KIRKLEES METROPOLITAN COUNCIL INVESTMENT & REGENERATION SERVICE

Reference No:	2025/62/91165/E
Site Address:	15, Dickinson Gardens, Eightlands, Dewsbury, WF13 2TT
Description:	Erection of two storey front and side extension
Recommending Officer:	Faiza Bano

HOUSEHOLDER DELEGATED REPORT

PROPOSED GROUND FLOOR PLAN
Scale 1:50@A1

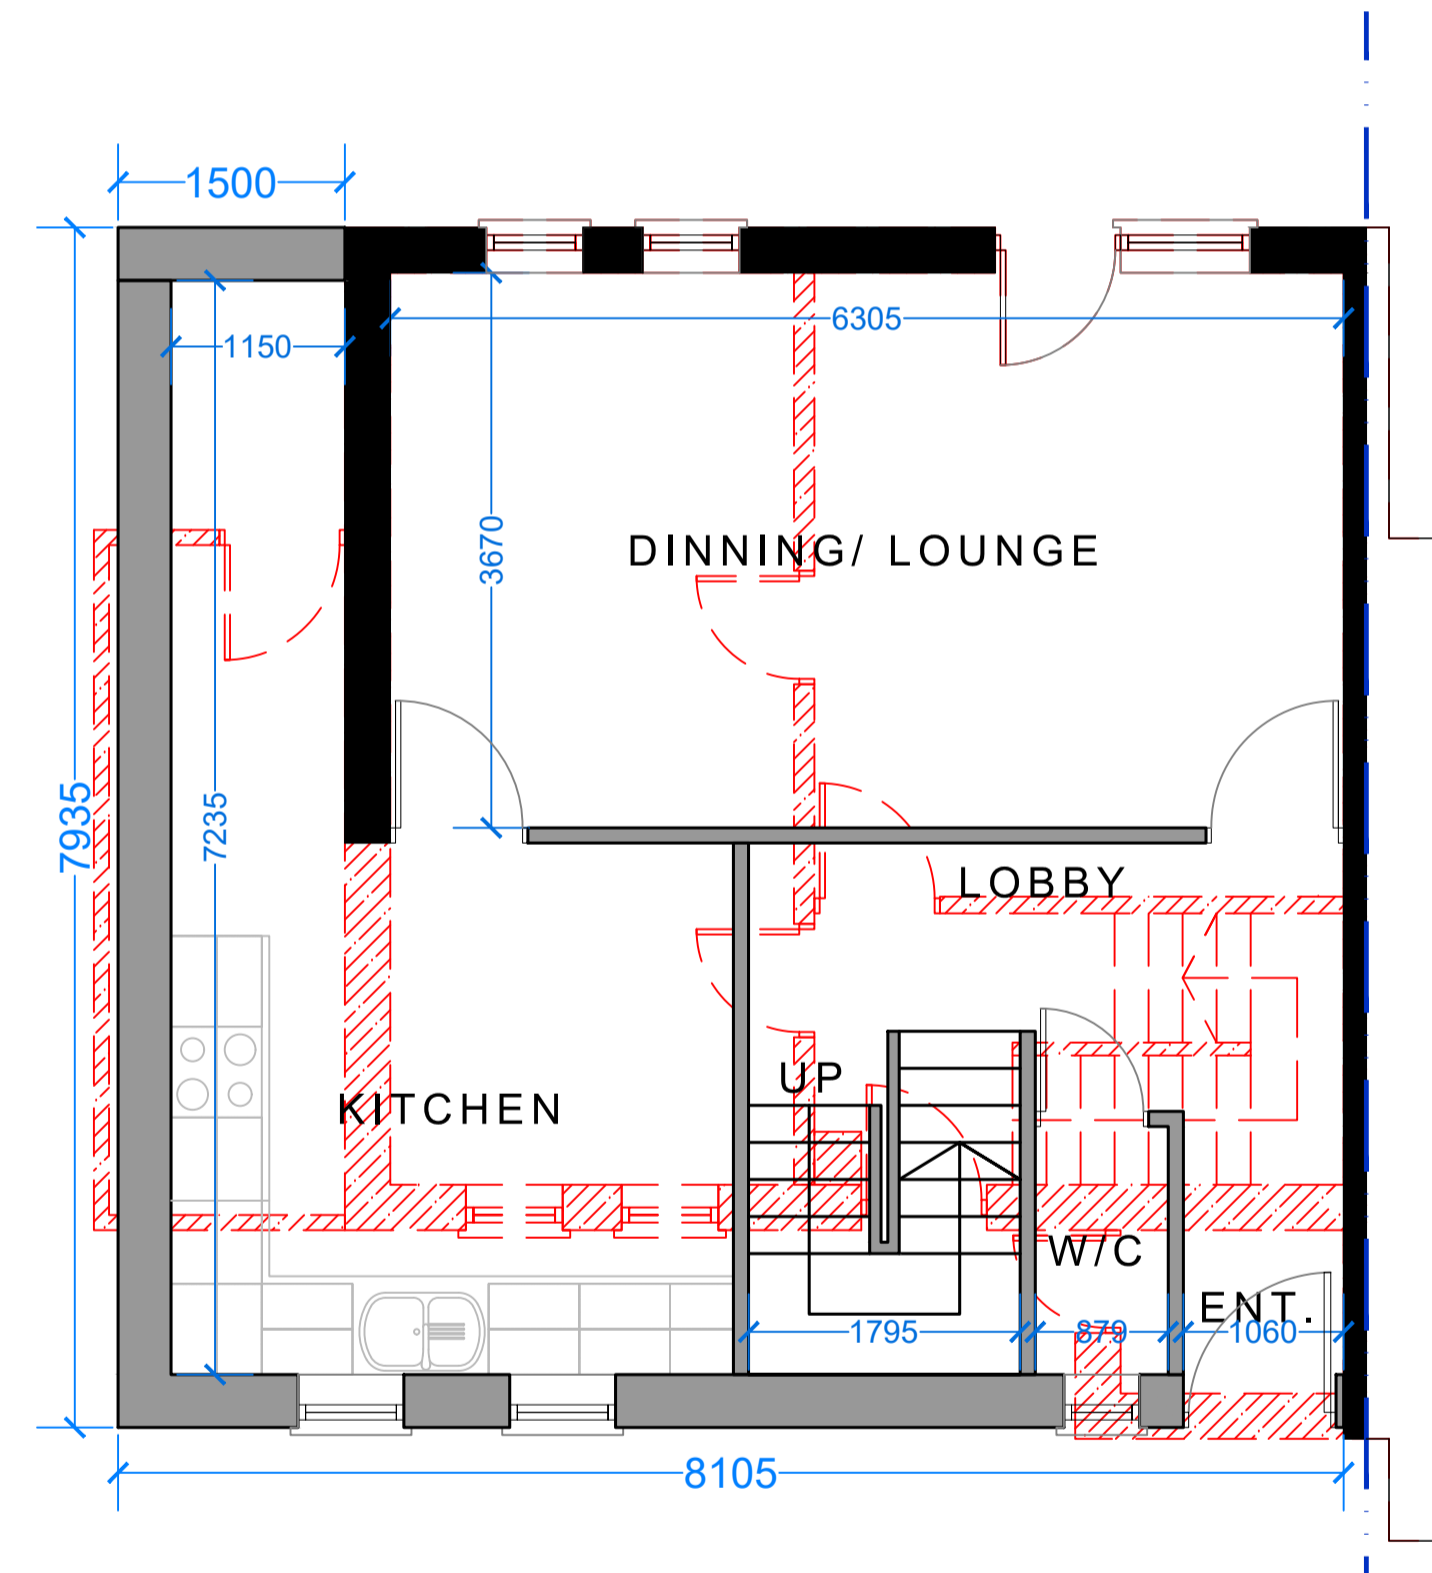
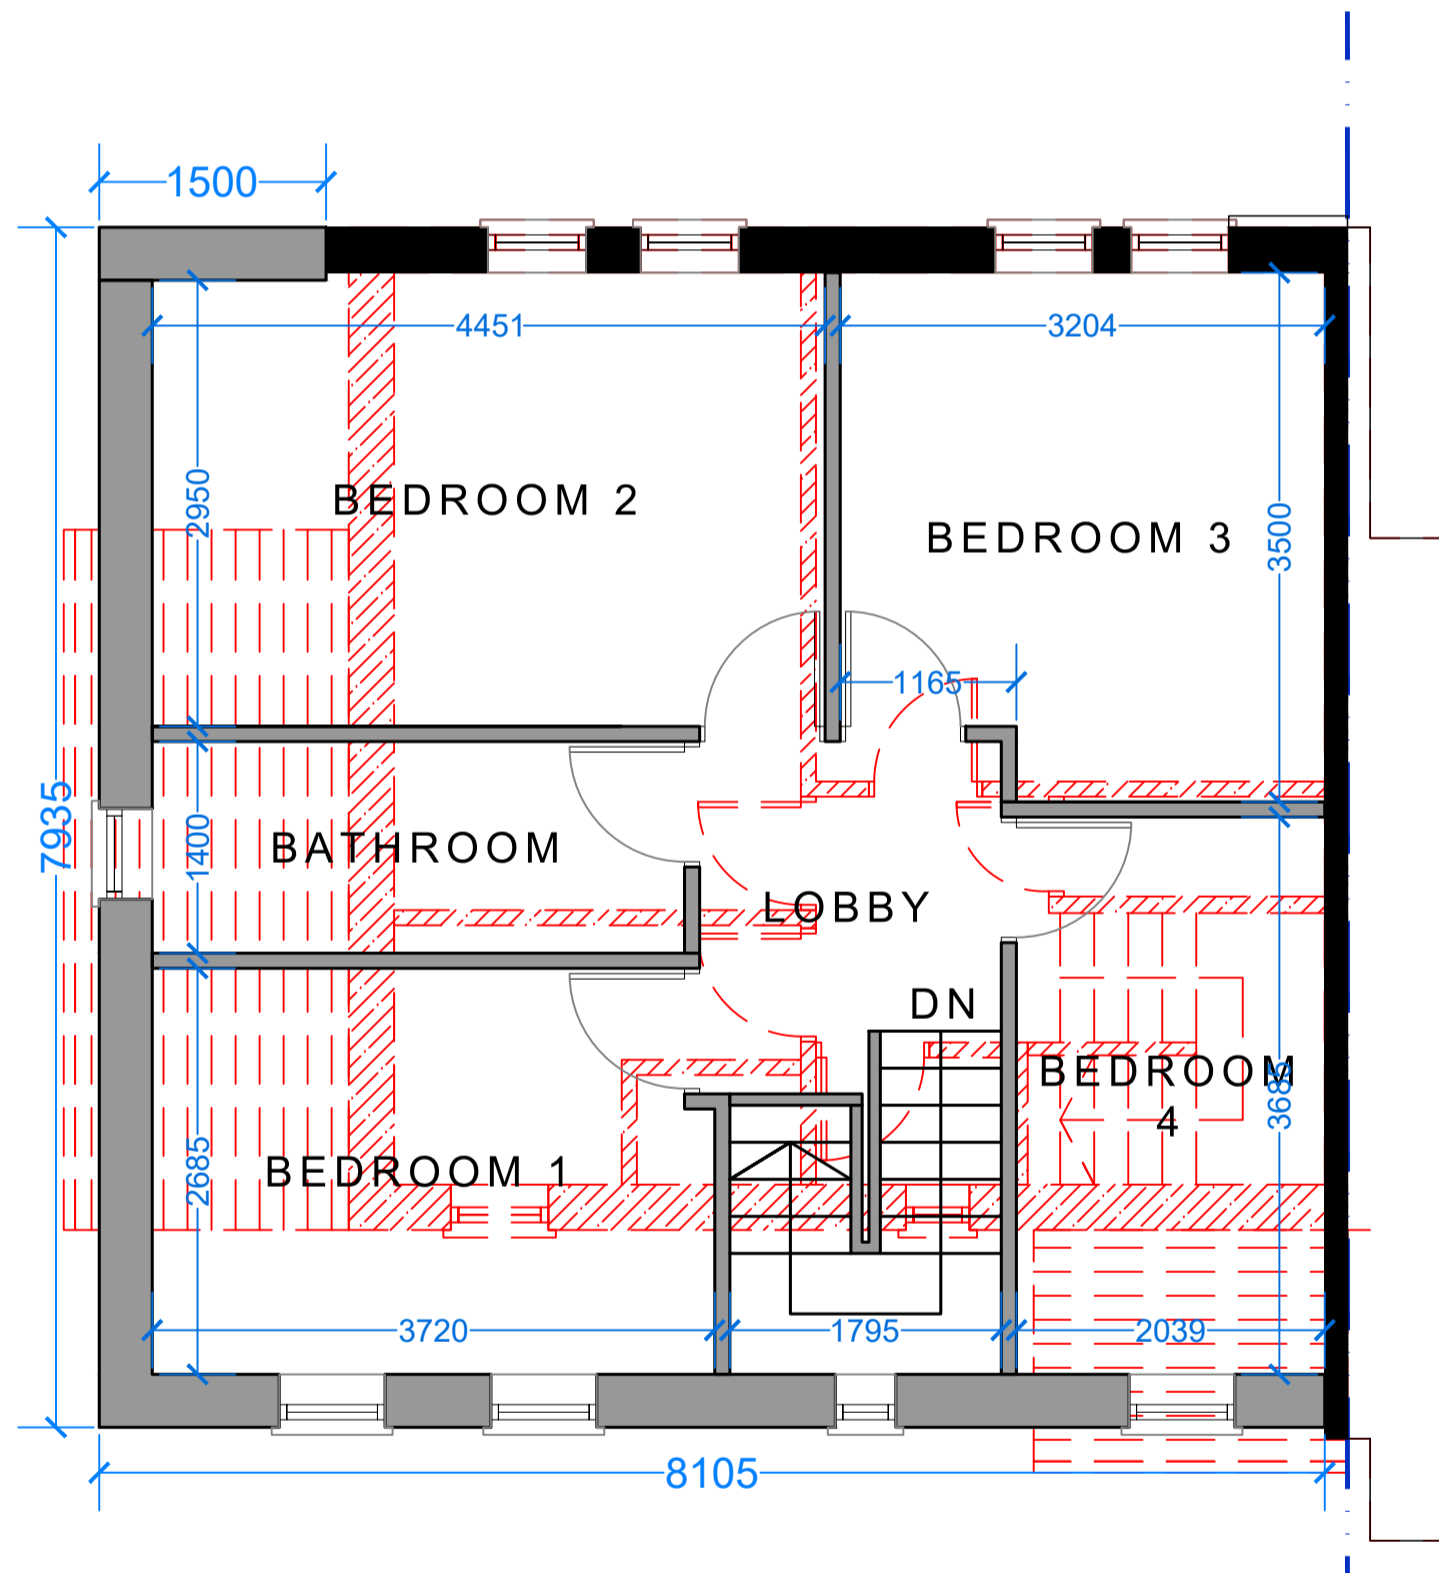
Two Storey Side Extensions Should:	<u>Yes - COMPLY</u>	<u>No - JUSTIFY</u>
not take up all or most of the space to the side of a house;	Yes – the extension does not cover more than half of the total area around the original house. The proposed extension projects out by approximately 1.65m which is in keeping with the SPD. Considered acceptable. Ample space will be retained to the front and rear of the house.	
maintain a 1 metre gap to the side boundary to ensure the building is not too close to a neighbouring property; and	N/A – the dwelling is a corner plot and it is considered a terracing effect would not occur as a result of the two-storey side extension.

PROPOSED FRONT ELEVATION
Scale 1:50@A1

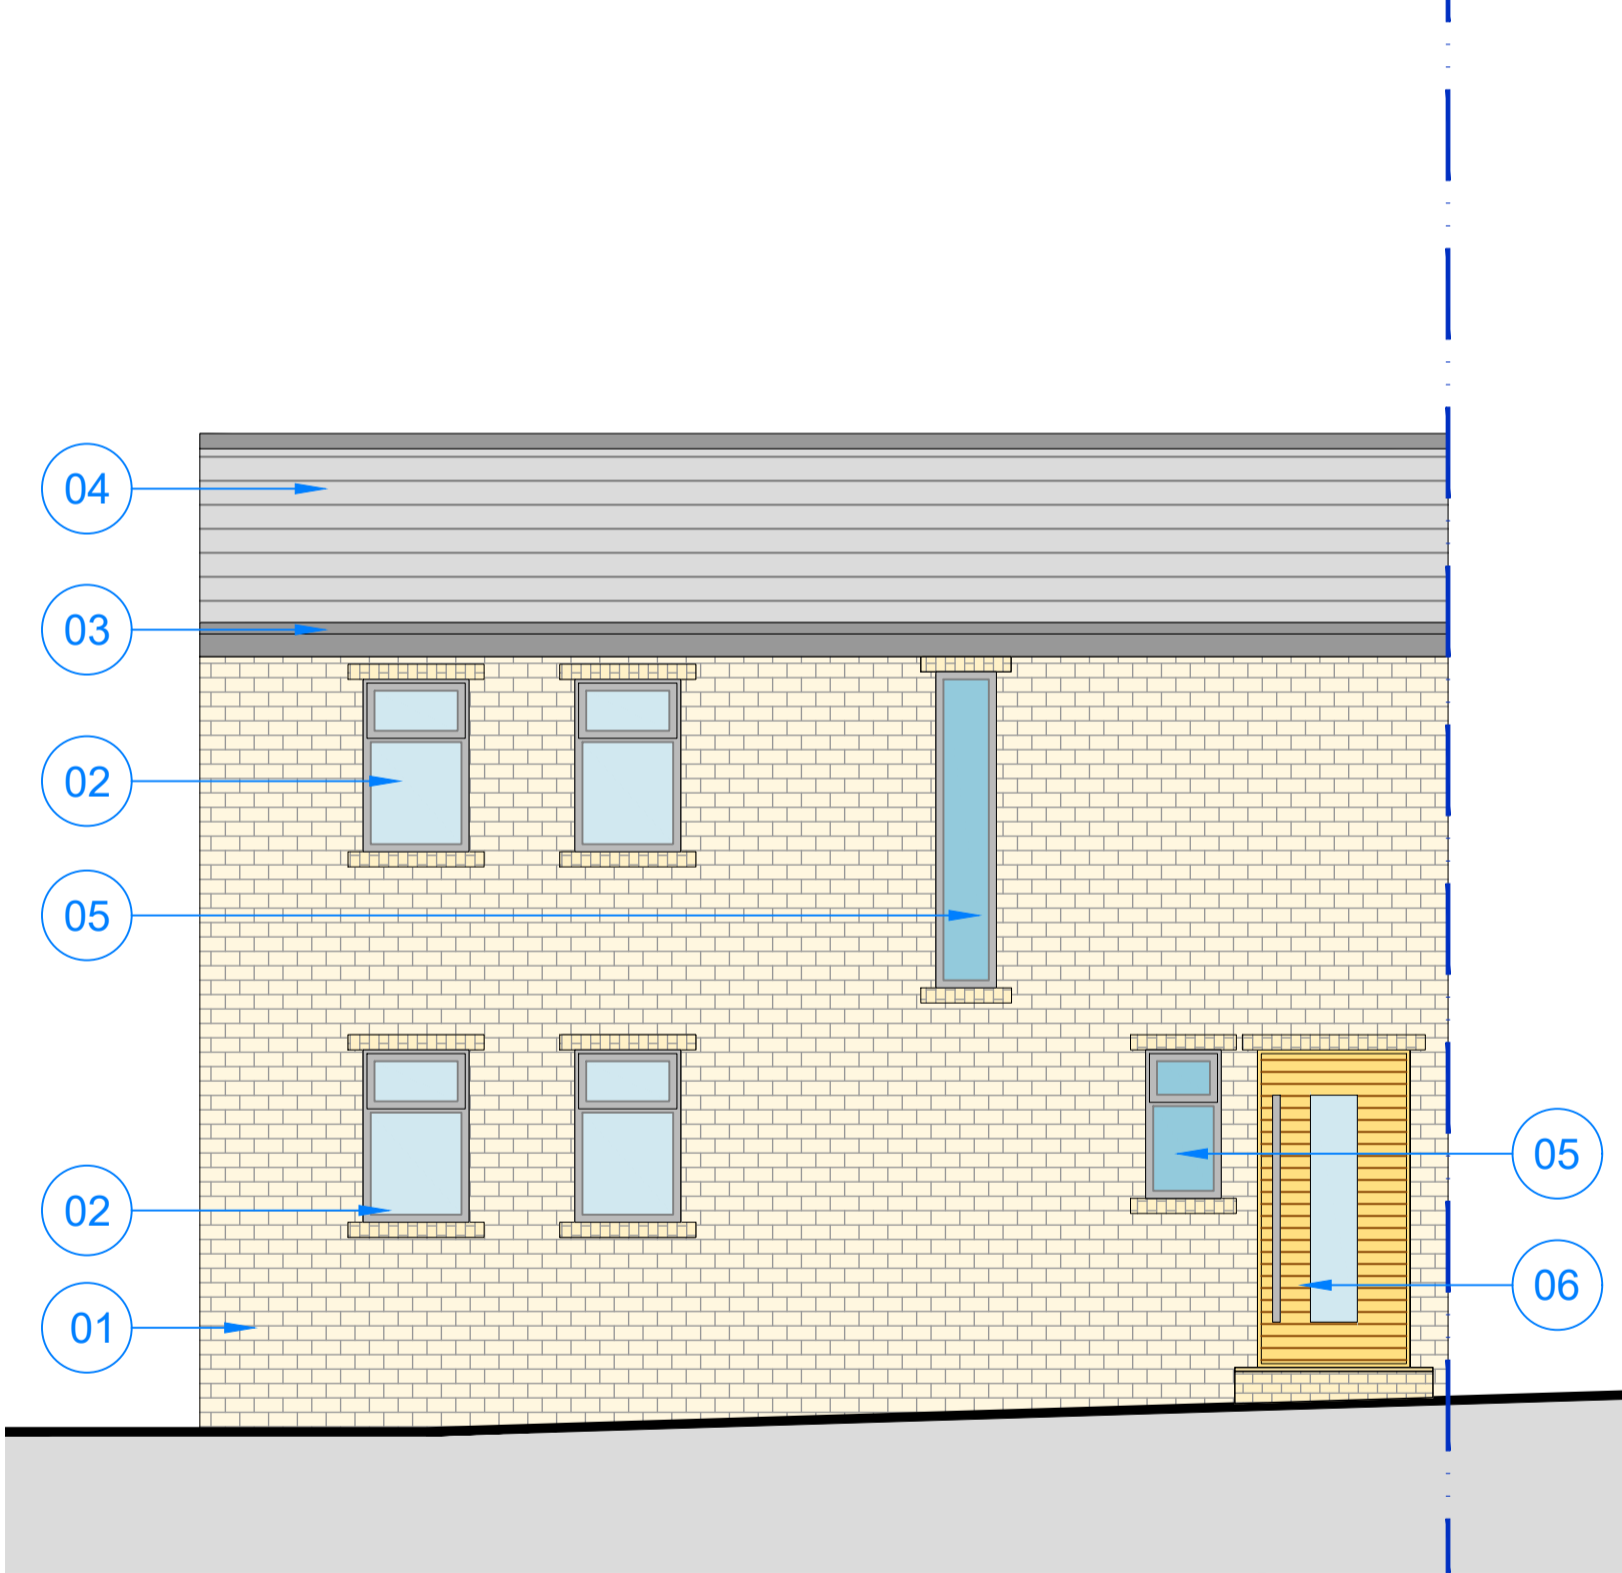
Two Storey Front Extensions Should:	<u>Yes - COMPLY</u>	<u>No - JUSTIFY</u>
ideally be visually smaller in relation to the original house;		No – the extension is in line with the ridge of the extension and the external walls. Weight is afforded to the individual style characteristics of the majority of dwellings on the street and whilst the host property is one of a small number of the same house type, the street is a mix of semi-detached and terraced dwellings of varying design.
be set back at least 500mm from the front of the original house to provide a vertical break from the roof plane and for the lowering of the ridgeline from the original house;		No - the house is set back from the pavement; the extension is not considered to cause detriment to the street scene whereby front projections are evident. The siting of the dwelling is not part of a linear form and as such in this case it is considered there is sufficient justification. Refusal based on the

impact of the two-storey element to the front could not be substantiated in this case.
have a roof design that follows the form of the existing roof; and	The proposed extension has been designed with a gable roof, in-keeping with the host property.	
retain a gap of at least 1 metre to boundary walls to avoid a terracing effect and to retain rear access to gardens.		No gap is retained, however, this is considered acceptable due to the host property sitting on a lower ground level to neighbouring property number 17. It is also considered that the front extension does not project beyond the front elevation of the neighbouring property and in this case, it would not seem reasonable to refuse the application on this basis.

be set back at least 500mm from the front wall of the house.		No – the proposed two storey side extension results in the creation of a front extension which would form a two-storey gable. In terms of this part of the development and the requirements of the SPD, the house is set back from the pavement, the extension is not considered to cause detriment to the street scene whereby (two-storey) front projections are evident.
--	--	---
